From: [NectonSubstationAction Messenger](#)
To: [Norfolk Vanguard](#)
Subject: Re: EN010079 – Application by Norfolk Vanguard Limited for an Order Granting Development Consent for the Norfolk Vanguard Offshore Wind Farm
Date: 19 October 2021 12:10:57

VANGUARD APPLICATION

NSAG

Indicative Onshore Project Substation
Mitigation Planting - Norfolk Vanguard

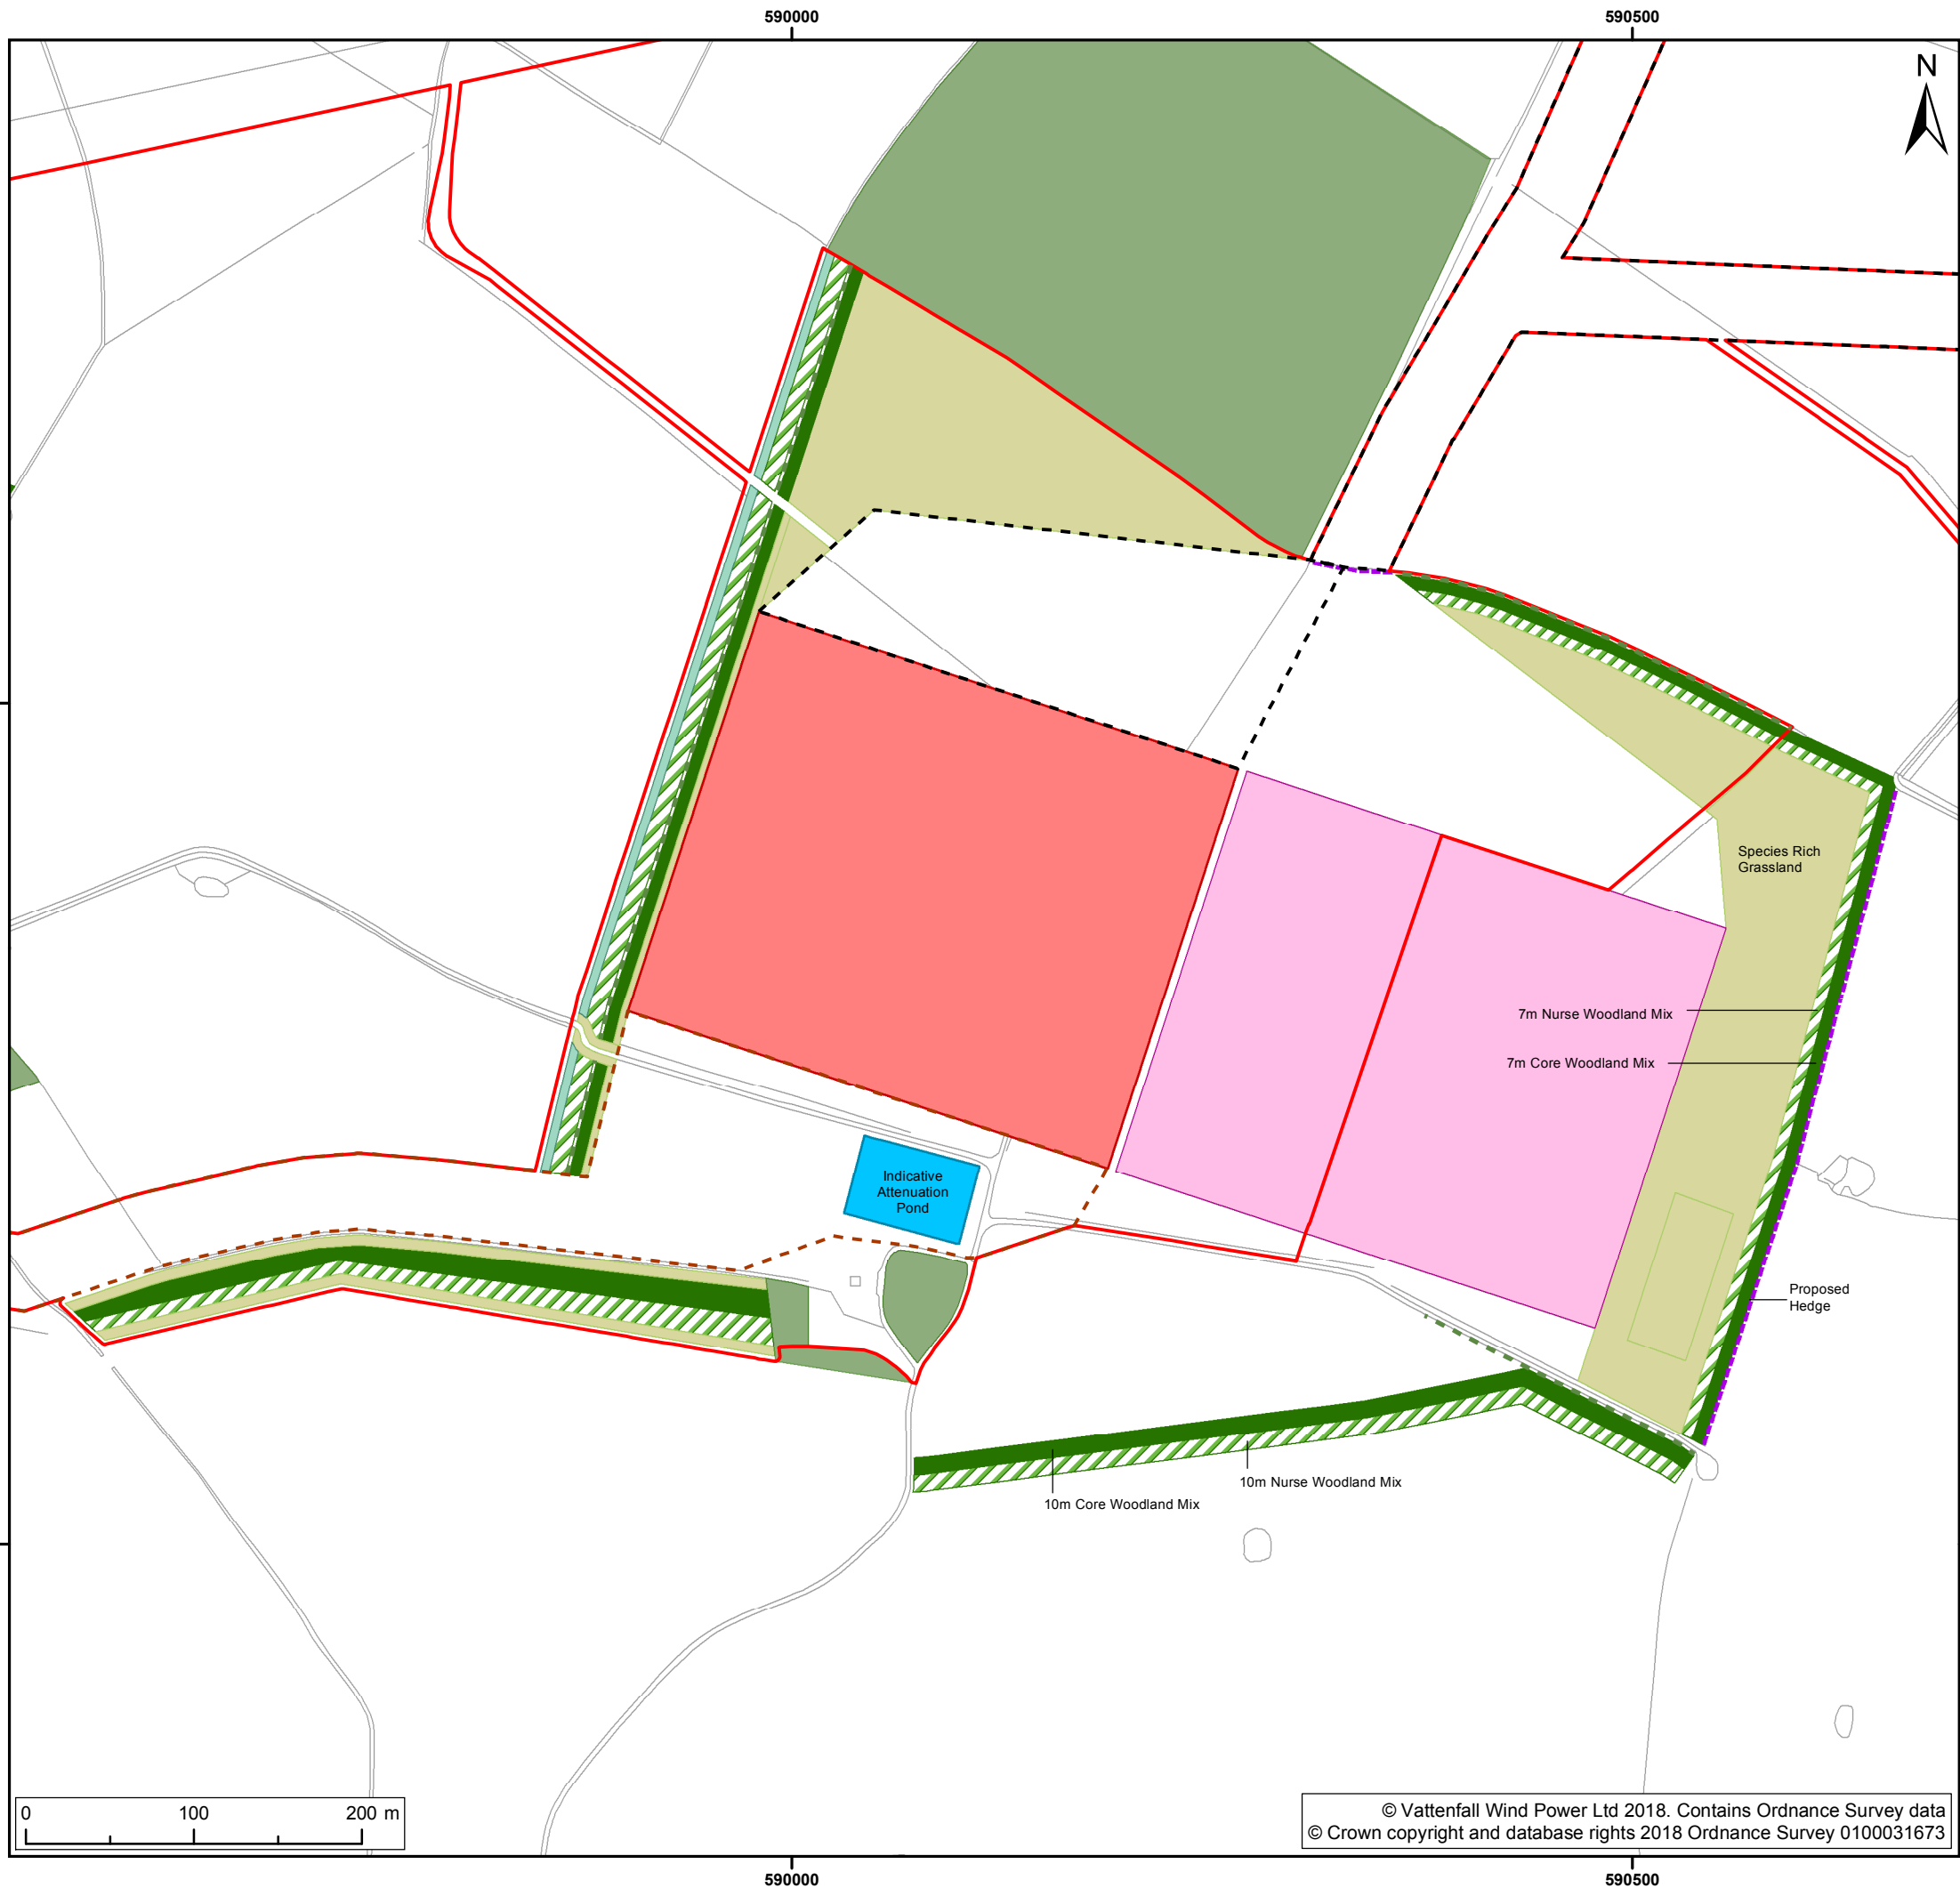
Mitigation of Substations in Necton – this subject has never been covered satisfactorily since day one. Without huge amounts of funding this project will be impossible to mitigate. The developer has clearly demonstrated that they have not set aside enough funding to achieve this. They have so far turned down green walls, (ie walls of planting to cover the outer walls of the larger structures), camouflage painting (by this we mean actual mural like paintings, not just dabs of random colours), which is available, underground substations (which are used quite a lot now), high bunds (earth banking of at least 6m high, which will cost a lot) planted with trees.
Cumulative effects with Boreas will double these problems.

Earth bunds were turned down as the developer claimed that Breckland Council said they did not fit in with the local landscape. Apart from the fact that Jon Berry of Breckland Council told us that he did not say this at any meeting he had before he left, there is also the fact that Planning Departments in Norfolk have agreed to many earth bunds throughout the county. The largest adorn the Northern Distributor road, to protect homes from noise and visuals. And a new housing development along the A47 in Little Fransham and in Necton have used large earth bunds to block the noise and visuals of the A47 from those houses. It is interesting to see that whilst the applicant has dismissed adequately high bunds to shield visuals of their own substations, they are planning to build a huge earth platform, possibly up to 5 metres high in order to level the very steep terrain of the site of their extension to the Dudgeon National Grid Substation for their Boreas application. How convenient this is for them.

As regards further information concerning the use of trees and earth bunds in the local area we direct the SoS's attention to this article recently published in the Eastern Daily Press [More than 500 trees on route on Norwich NDR have died | Eastern Daily Press \(edp24.co.uk\)](http://www.edp24.co.uk) "A further 500 trees and shrubs, which were planted along the route of the Norwich Northern Distributor Road, have died, council bosses have confirmed. Work to replace them will start next month, but it means more than 3,500 trees and shrubs planted next to the road since 2016 have perished." This comment and others like it in the article confirm that trees alone are not suitable to be considered as mitigation for projects' visual impacts. Other developers in the Necton area have used high earth banks (bunds) with a lot more success than they have trees alone.
